PROJECT NAME & NUMBER 1003268

La Villita Subdivision

City of Albuquerque
Parks and Recreation Department
PO Box 1293, Albuquerque, New Mexico 87103
Inter-Office Correspondence
Development Review Board Comments

DEVELOPMENT REVIEW BOARD TRANSPORTATION DEVELOPMENT Standard Comment Sheet

<b>LAS VILLITAS NUEVAS SKETCH PLAT</b>		
SHT: 1 OF 1		
DRW: R.M	TR:	DATE: 02/24/04
CKD: P.T.B	OK:	SCALE: 1"=20'
APP:	ACAD FILE:	
REV. NO.	01553-GD.DWG

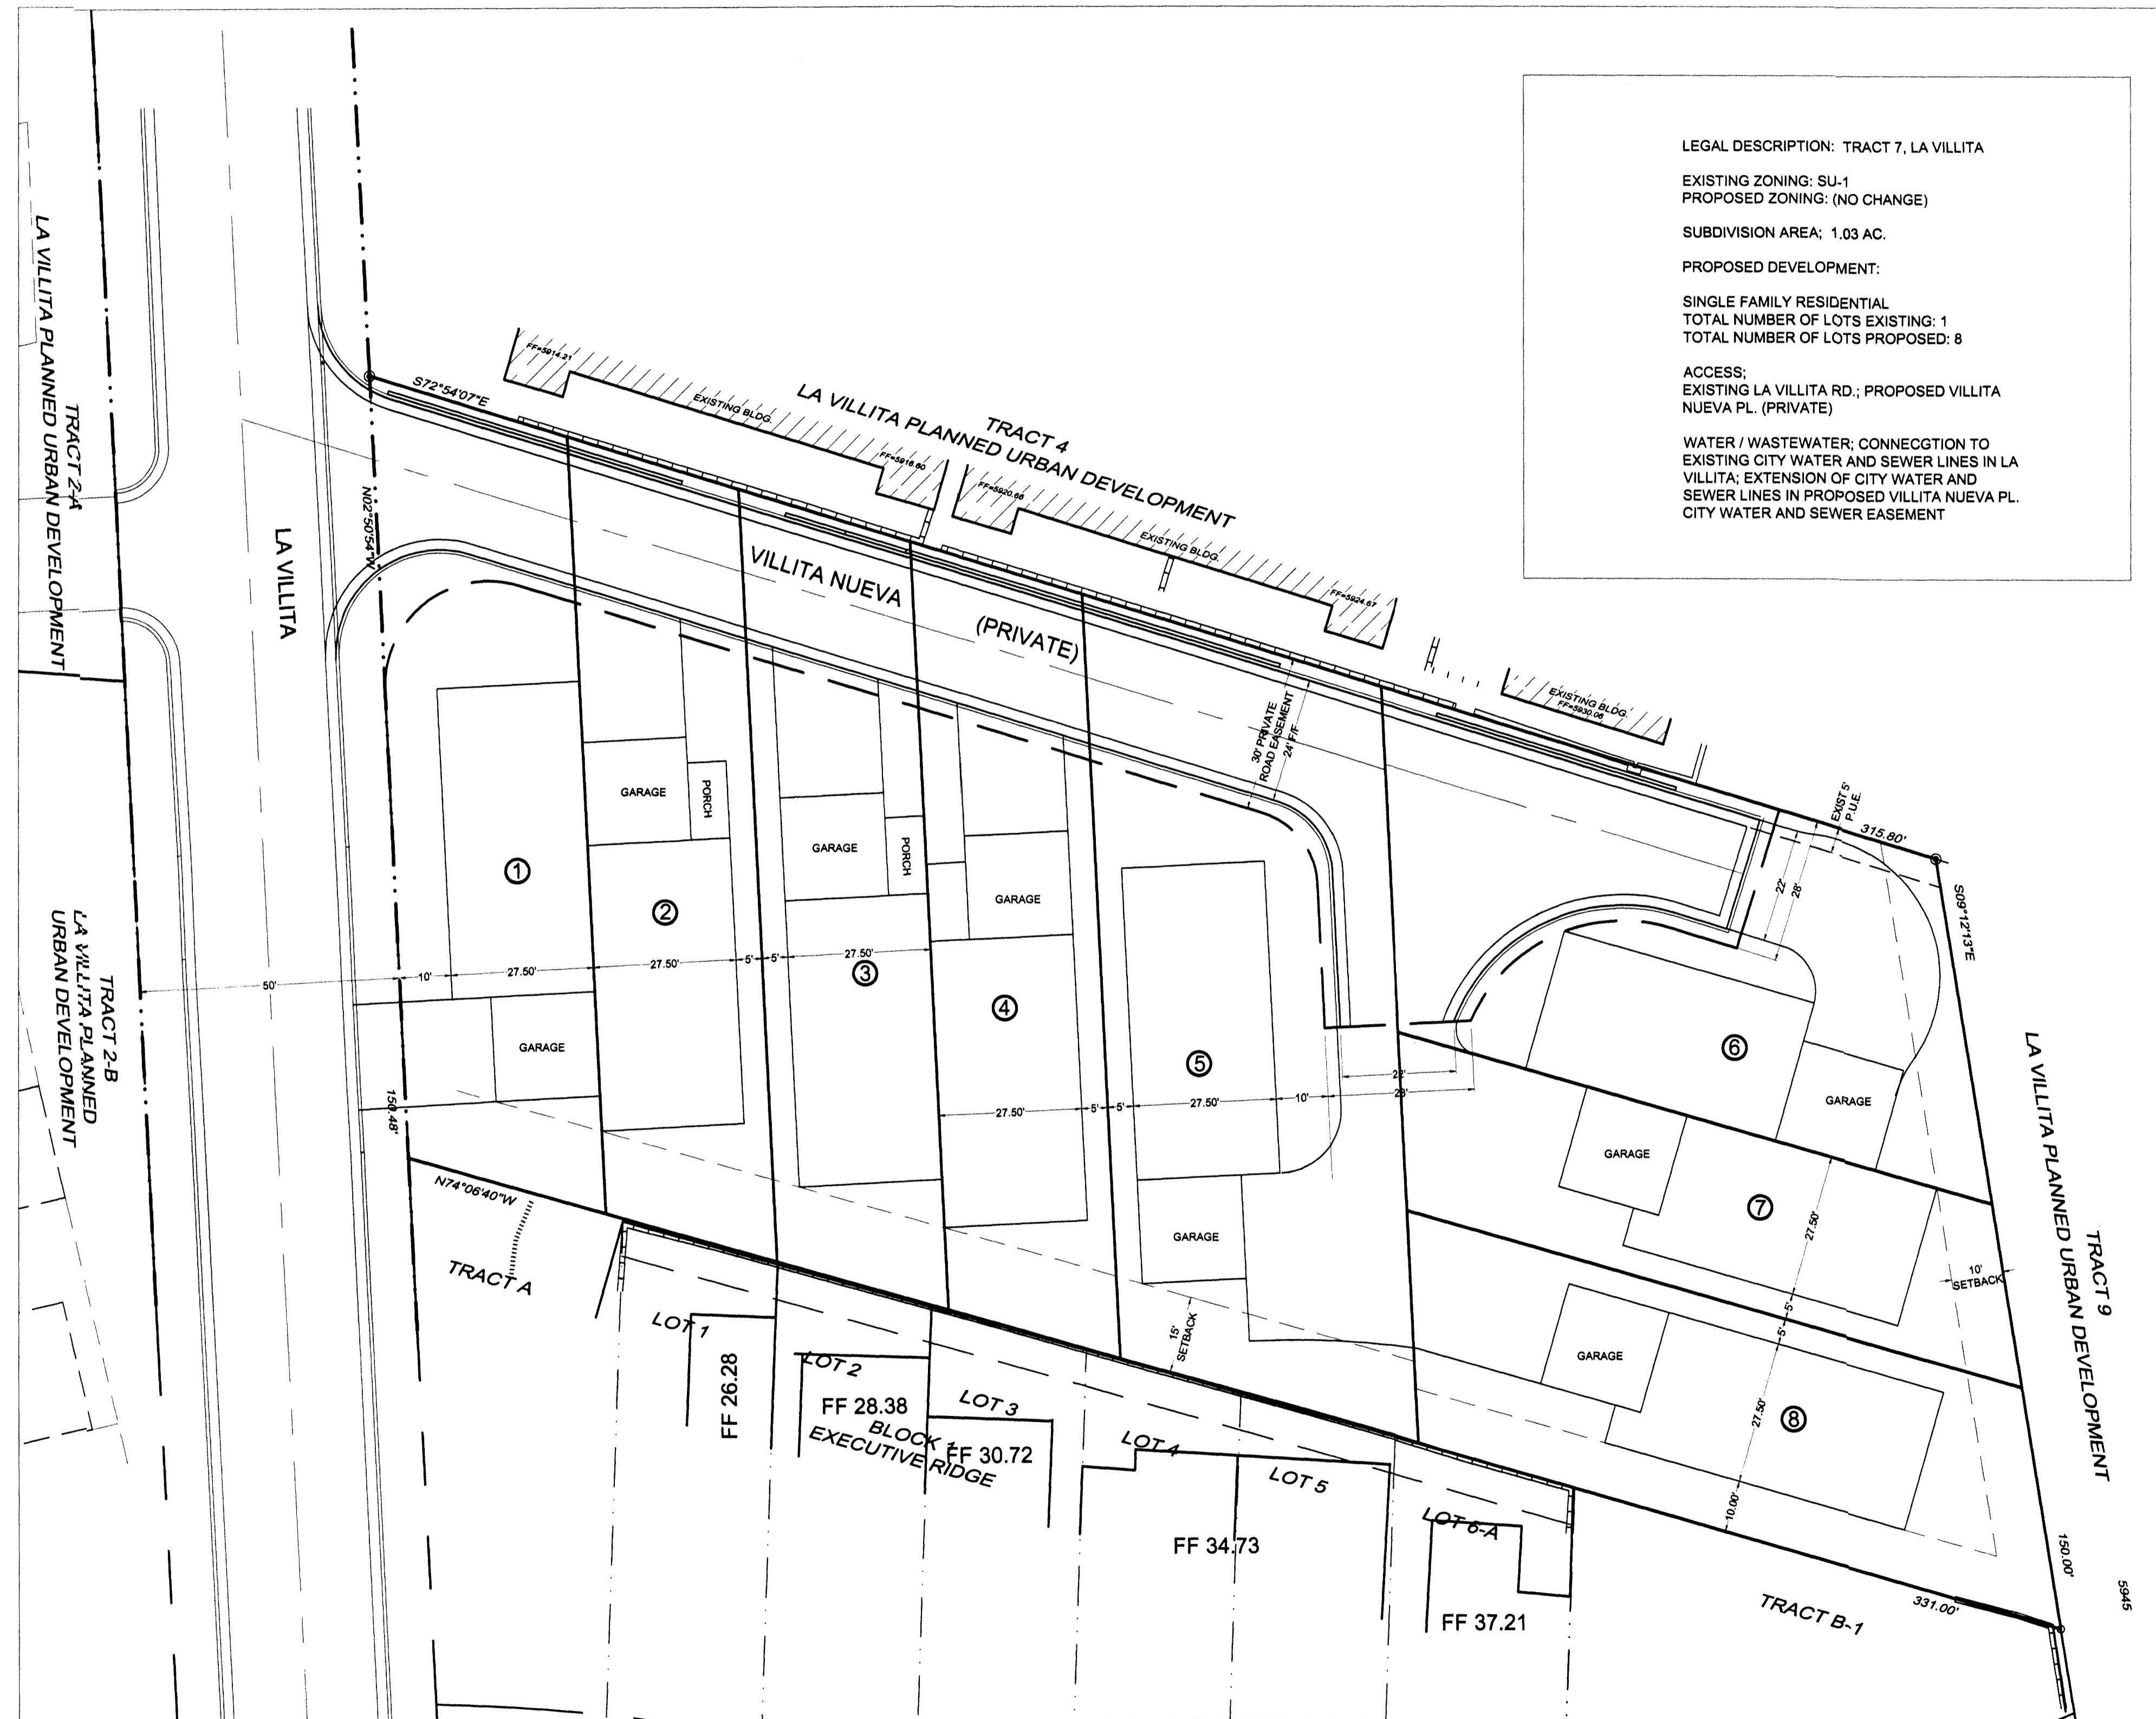
No.	Comment
①	STANDARD INFRA. REQ'D
②	8 LOTS REQUIRES SWALK HOW DOES TRACT 4 TAKE ACCESS
③	FIRE & SOLID WASTE AGED TO APPROVE TRACT-AROUND
④	VARIANCE IS AGED FOR EASEMENT AGED
⑤	LIST MAINT. & BENEFICIARIES OF PRIVATE ROAD
⑥	AGED TO DEFINE EASEMENT FOR LOTS 5, 7 & 8
⑦	ARE IMPROVEMENTS IN PLACE ON LA VILLITA?
⑧	ARE THE P1 LOTS? (PARKING)

1. Public water and sewer lines must be extended. Water line must be looped, dead end lines are not allowed unless waived by the City Engineer.

An approved drainage plan is required for Preliminary Plat approval.
 An approved infrastructure list is required for Preliminary Plat approval.
